Item No. **Report of the Head of Planning, Transportation and Regeneration**

Address 12 DAWLEY AVENUE HILLINGDON

Development: Two storey side extension, conversion of roof space to habitable use to include a rear dormer and a front roof light, and alteration to elevations of the rear extension

LBH Ref Nos: **17948/APP/2021/3995**

Proposed front elevation

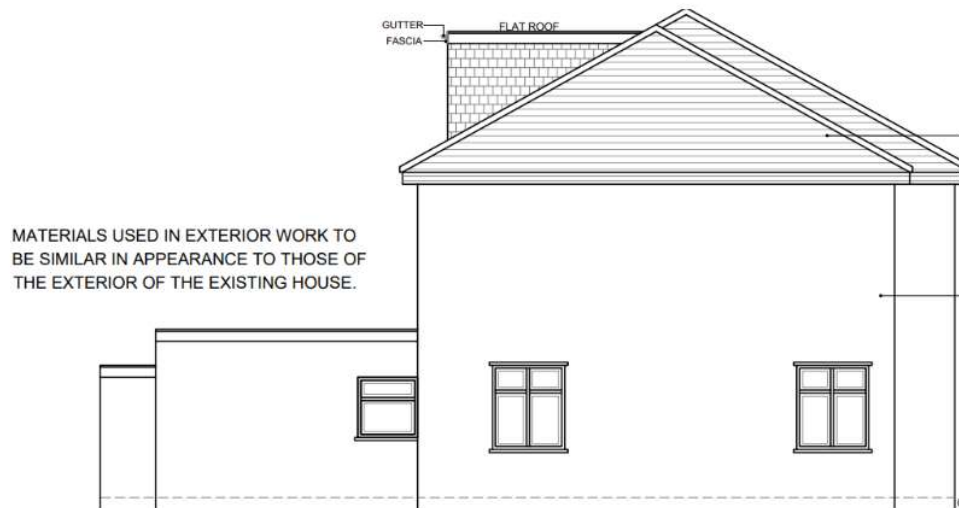
The proposed two storey side extension takes on board some of the policy requirements of Policy DMHD 1. The extension would retain a 1 metre gap from the side boundary and have a 1m set back from the front elevation. However, considering Policy DMHD 1 and DMH B 11, these elements alone would not be sufficient to comply with the development plan as a whole and there are no material considerations to warrant such a stark departure from policy in this case.

The property is located on a sensitive corner plot. Policy requires that this type of property should retain the openness of the plot to preserve the character and appearance of the streetscene and wider area. There are no similar examples nearby on similarly designed properties. On this exposed corner, the proposed extension will not appear to be subordinate to the host dwelling and would be overly dominant and incongruous in the street scene. The design would be out of character and no examples nearby dilute the harm identified.

Taking into account the design, character and appearance of the proposed scheme, the development would not be appropriate as it would result in an incongruous, dominant, disproportionate, bulky and visually intrusive addition that would fail to harmonise with the architectural composition of the original dwelling and would be detrimental to the character, appearance and visual amenities of the street scene and the surrounding area. The harm is further exacerbated by the fact it unbalances the row of properties it forms part of. The original catslide design and roof would be removed entirely. There is no subordination, no reference to the original architectural qualities of the building and no preservation of the open corner. The side extension is therefore harmful in visual terms.

Proposed loft plan

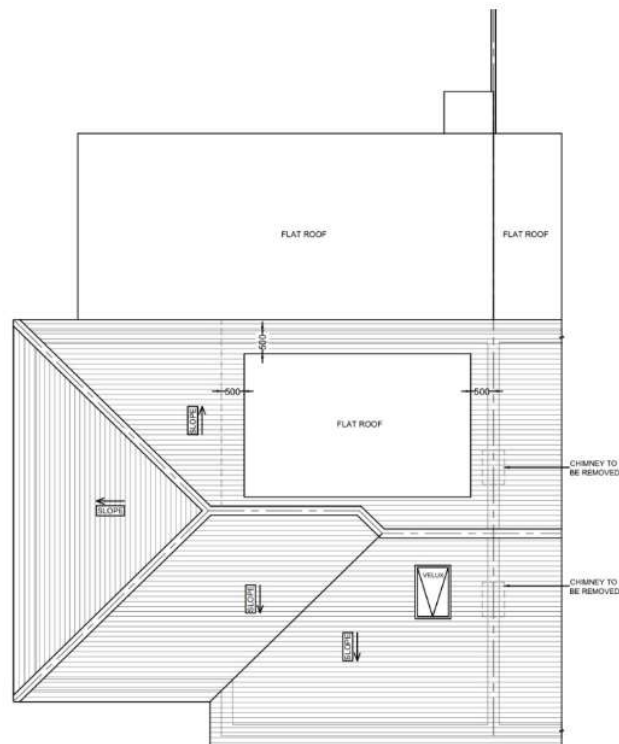
The dormer is also very large and adds to the dominance, bulk and visual harm of the extensions as a whole. The dormer fails to comply with the requirements of Policy DMHD
